From: Anita Gardner
Sent: 07 February 2011 11:58
To: Planning.Responses
Subject: FW: New dwelling - Seanormous, Rope Walk, Littlehampton - LU/386/10

Subject New dwelling - Seanormous, Rope Walk, Littlehampton - LU/386/10

Title PROPOSED FLOOR
AND ROOF PLAN

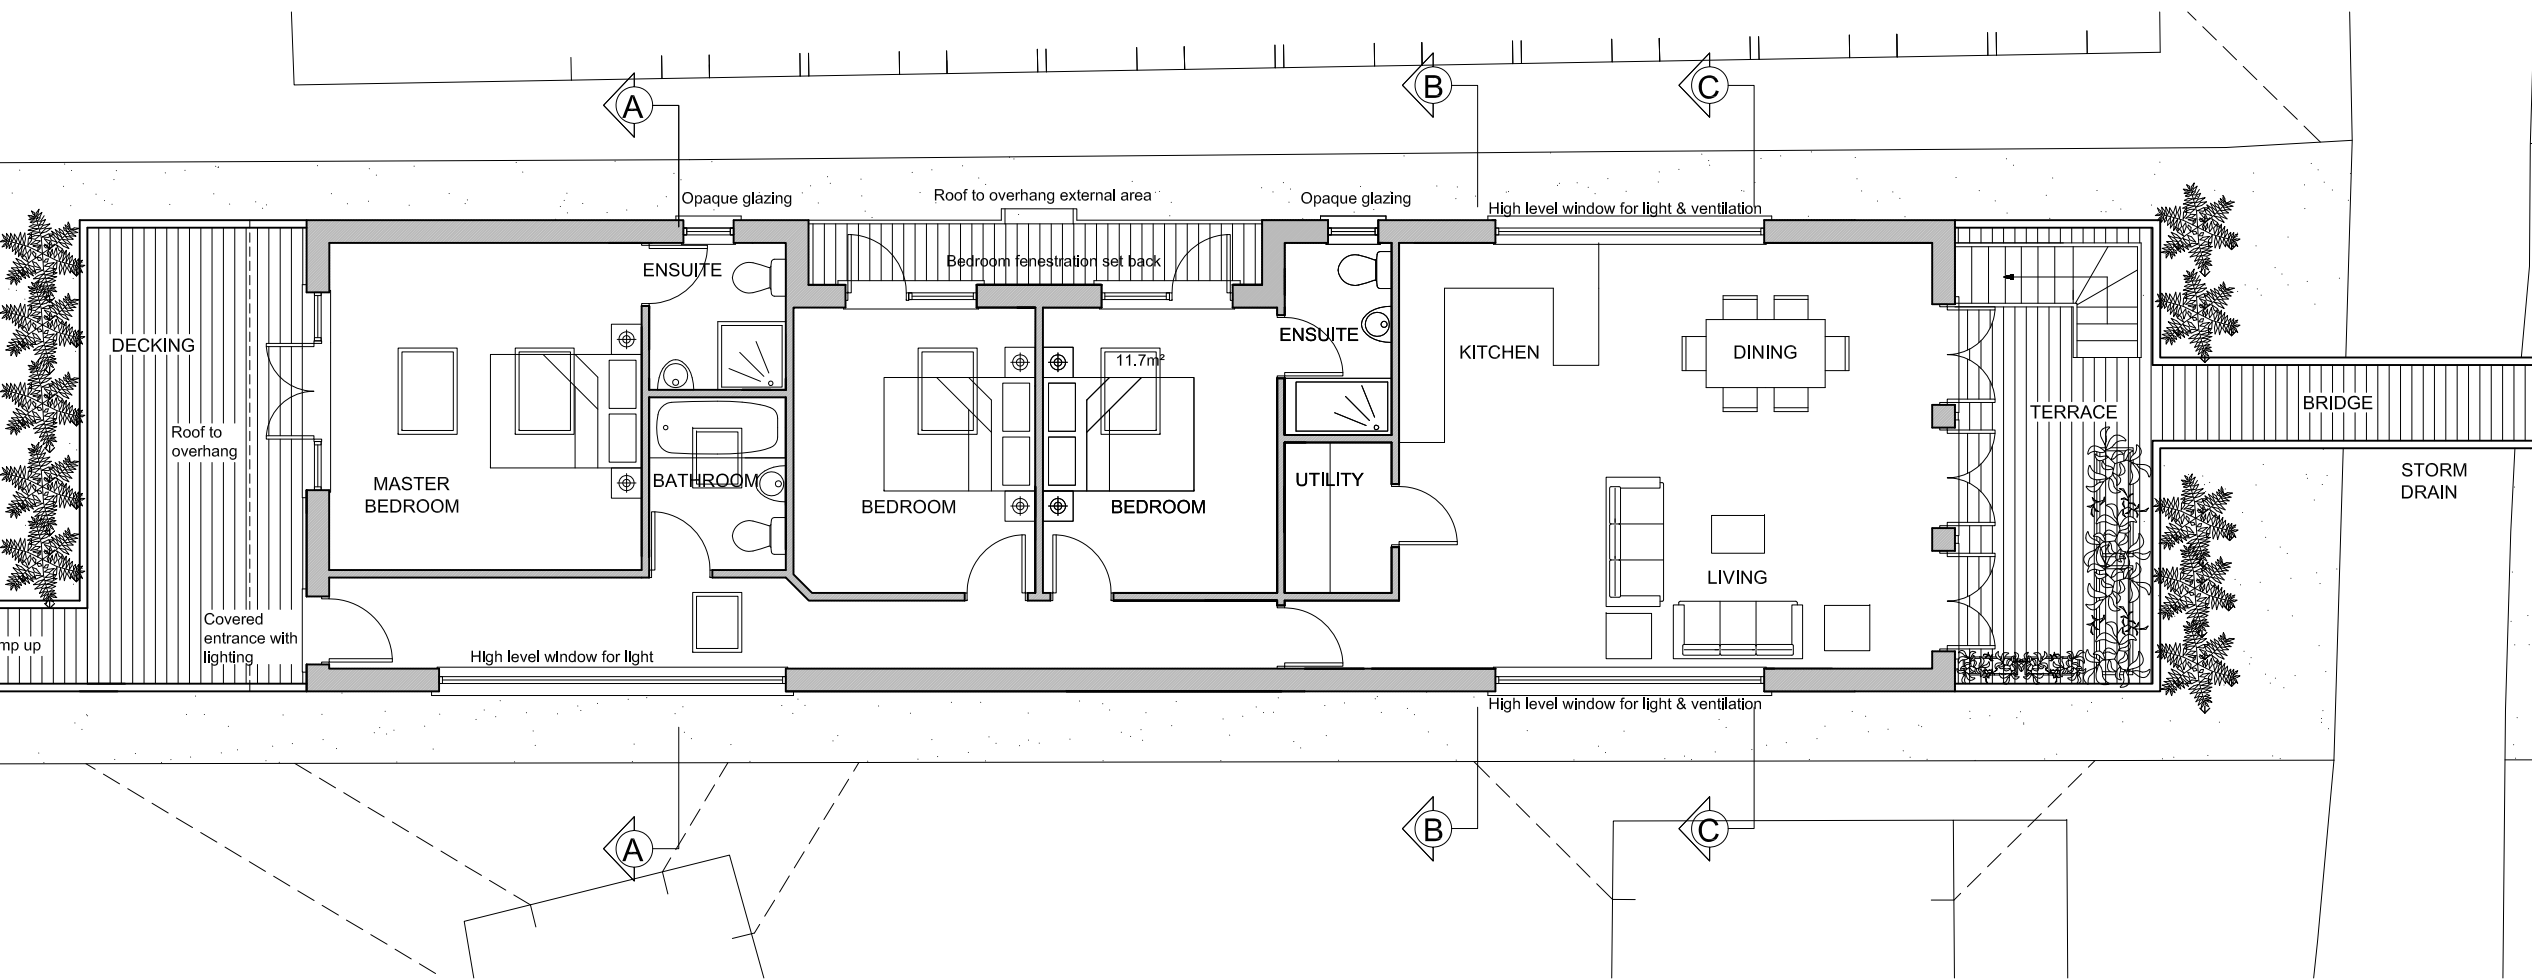
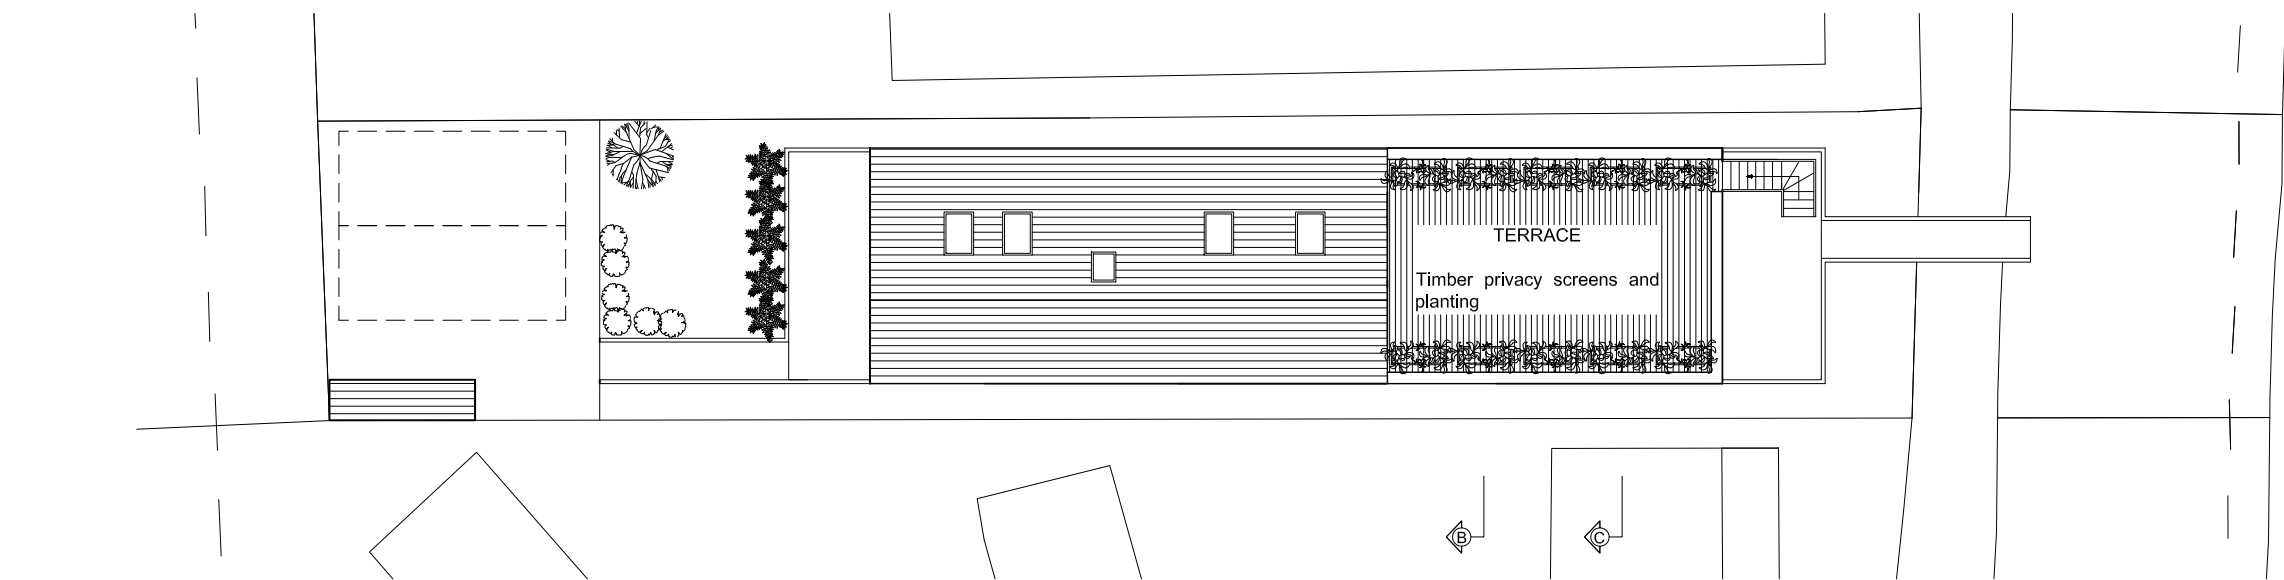
Liam,
I have received your consultation response. The 2 parking spaces are indicated on the roof plan. Is this information satisfactory or would you like me to request additional info from the agent ?

If the 2 rectangles are indeed parking bays then no further information would be required. The existing crossover would be adequate to serve the spaces.
